DOC17/314742
DA 344-11-2001 MOD1

Wallerawang Quarry Modification 1

I refer to your email dated 25 May 2017 to the Office of Environment and Heritage (OEH) inviting comment on the proposed modification for the Wallerawang Quarry.

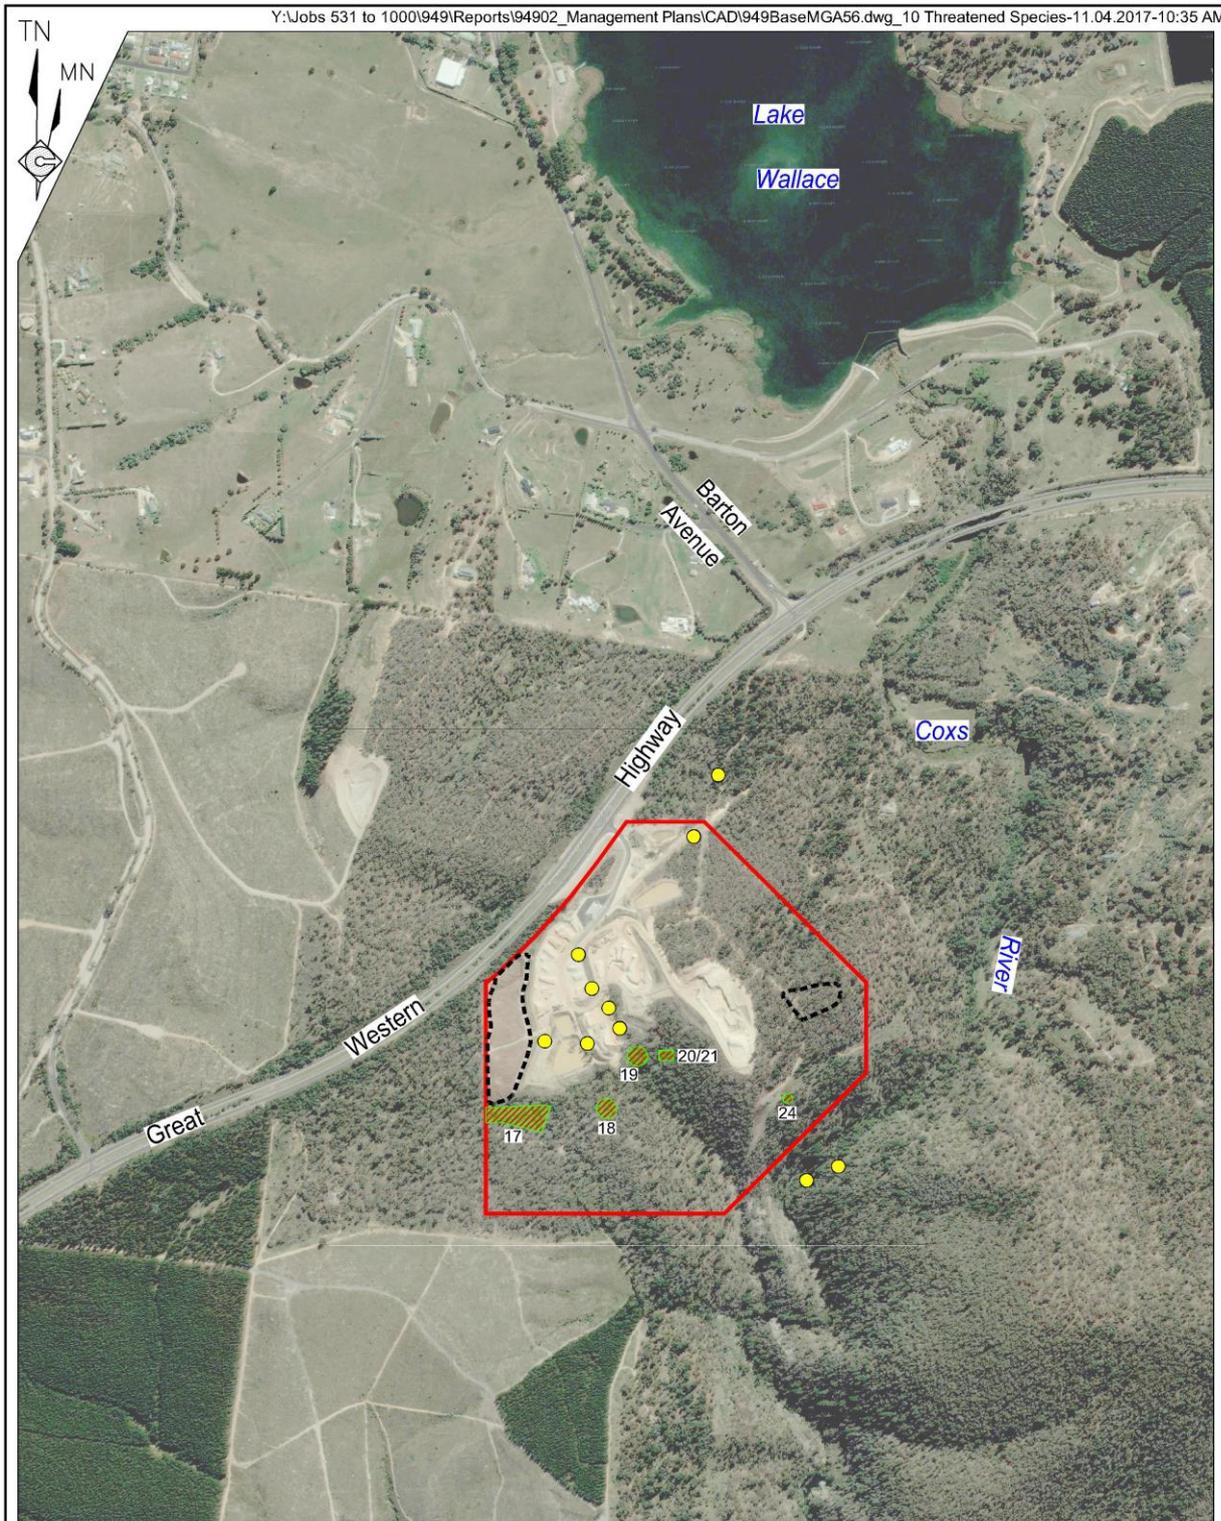
Neither of the monitoring plot locations were identified by the proponent in the Ecological Investigation, and it appears that no random meander transect was undertaken around the ESEA. Many blackthorn and purple copper butterfly records exist within or immediately adjacent to the quarry site. Figure 13 of the Environmental Assessment (main report) indicates that some blackthorn sites may be located within 100 metres of the ESEA.

The proponent should provide additional evidence to support their claim as to why habitat was unlikely to have been present. This should include as a minimum searching within 100 metres of the ESEA boundary for the occurrence of blackthorn and reporting the results in the RTS report.
